ENTECH
ENGINEERING, INC.

August 27, 2026

Re: Response to El Paso County Review Comments
Monument Ridge East
Monument Hill Road and Palmer Divide Road
El Paso, Colorado
Entech Job No. 230248

Ref: Entech Engineering, Inc., revised date July 16, 2026. *Soils and Geology Study, Monument Ridge East, Monument Hill Road and Palmer Divide Road, El Paso County, Colorado.*
Entech Job No. 230248.

Exhibit 1: Temporary Piezometer Measurements – Monument Ridge East

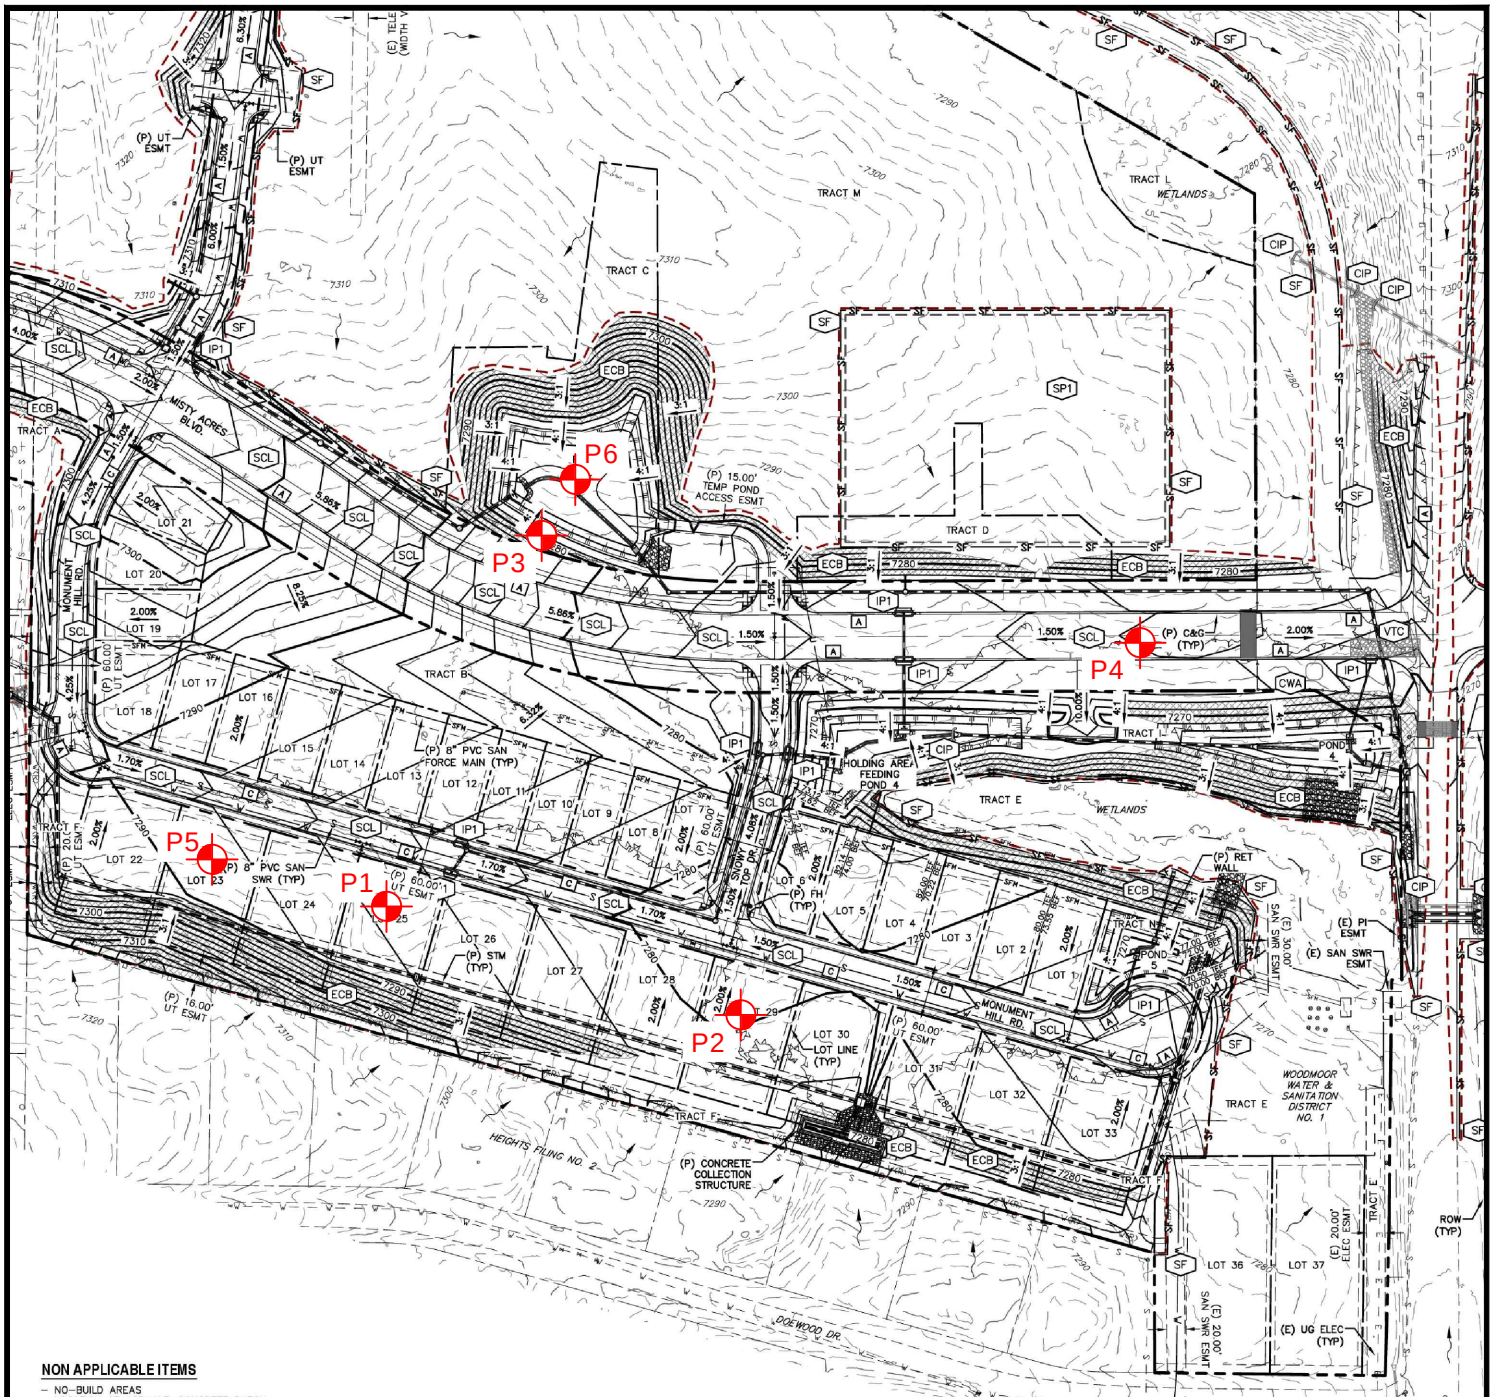
When will groundwater be determined for construction? Will testing be done prior to construction, early grading, or during construction? If groundwater is encountered within 5 vertical feet of public ROW or drainage facilities, additional reports and testing will be required to address shallow groundwater. (See ECM C.6.1)

- It is our understanding that underdrains will be installed on the site. In areas where water is in close proximity to foundation grade additional drains will be required. Drain details for underslab and interceptor drains have been included in the Soils and Geology Study.
- Entech will continue to monitor the temporary piezometers throughout the coming seasons and during the development process. Additional site subsurface investigations will be performed as development is completed. Additional piezometers will be completed as needed.

Entech installed two additional piezometers on July 21, 2026 (P5 and P6). P5 was placed on proposed Lot 23, and P6 was placed in the bottom of Pond 2. The locations of the piezometers for the site are shown in the Piezometer Map, Figure 1. The test boring logs for the two additional piezometers are included in Appendix A, and Laboratory Testing Results are included in Appendix B. Piezometer readings for the development are included in Exhibit 1.
